Ribble Valley Borough Council
By email

Your ref: 3/2023/0153
Our ref: DC/23/857
Date: 20-MAR-23

Location: Old Row Whalley Road Barrow BB7 9AZ

Proposal: Proposed erection of a 66 bed care home (use class C2) for elderly people with associated parking

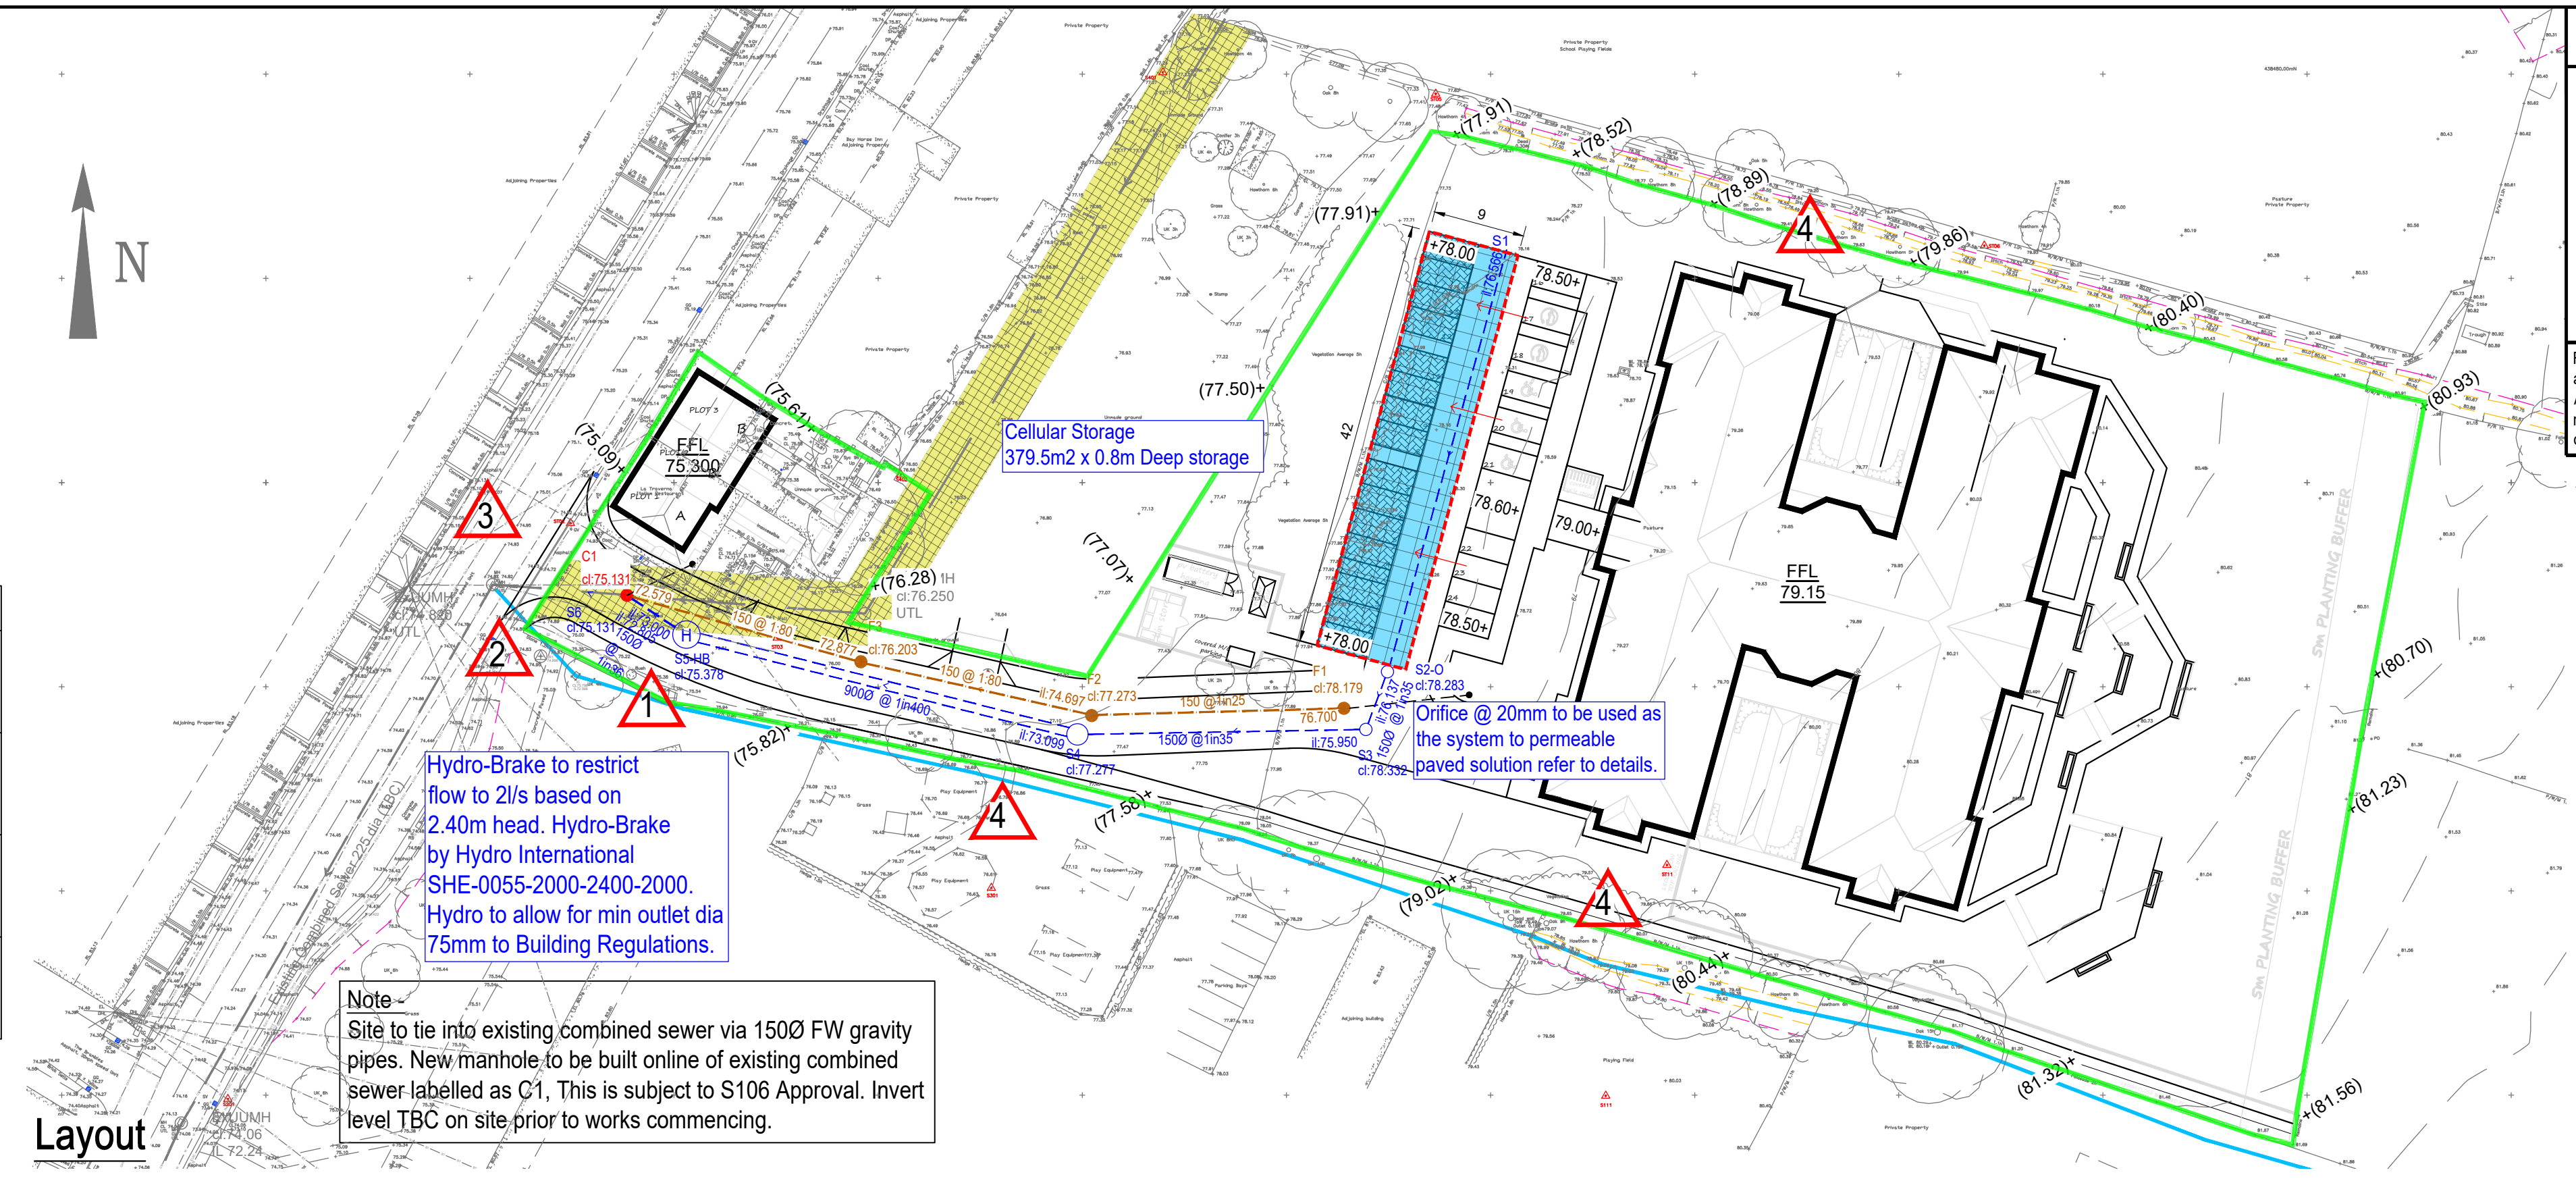
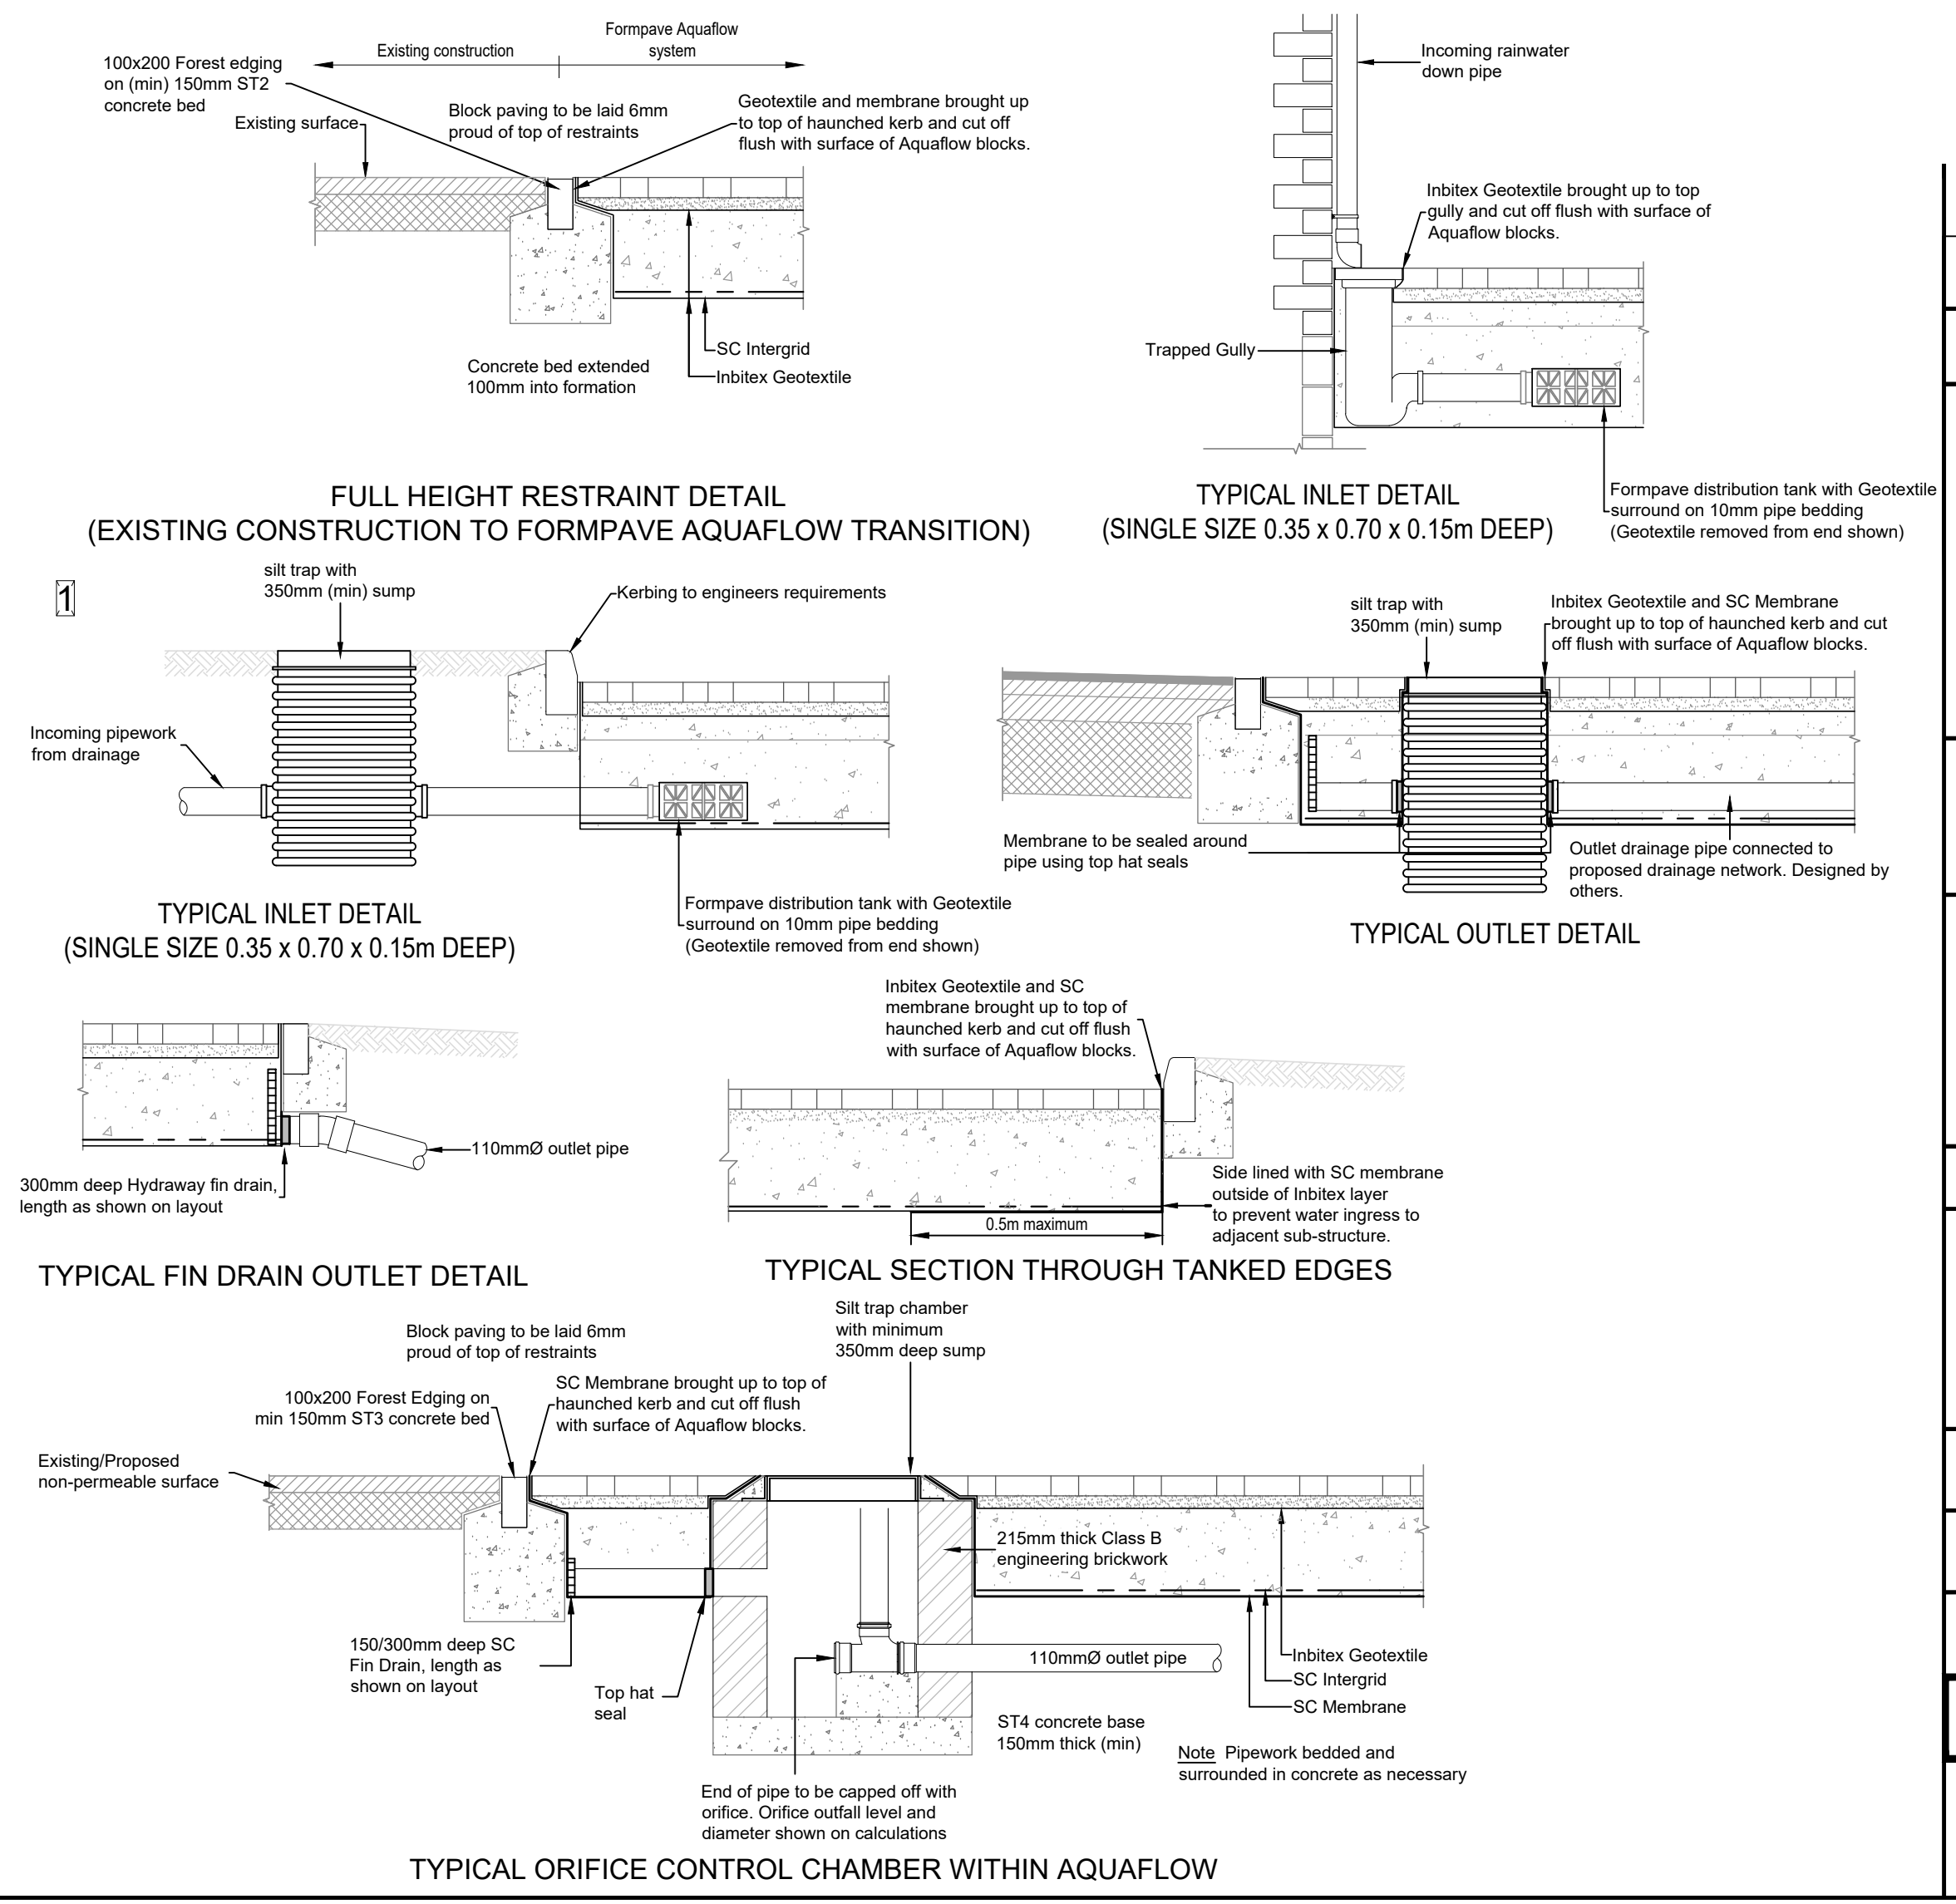
Following our review of the submitted Drainage Strategy, we can confirm the proposals are acceptable in principle to United Utilities and therefore should planning permission be granted we request the following condition is attached to any subsequent Decision Notice:

The drainage for the development hereby approved, shall be carried out in accordance with principles set out in the submitted Foul & Surface Water Drainage Design Drawing 882667/10-01, Rev P1 - Dated 25/01/2023 which was prepared by RSK. For the avoidance of doubt surface water must drain at the restricted rate of 2l/s. Prior to occupation of the proposed development, the drainage schemes shall be completed in accordance with the approved details and retained thereafter for the lifetime of the development.
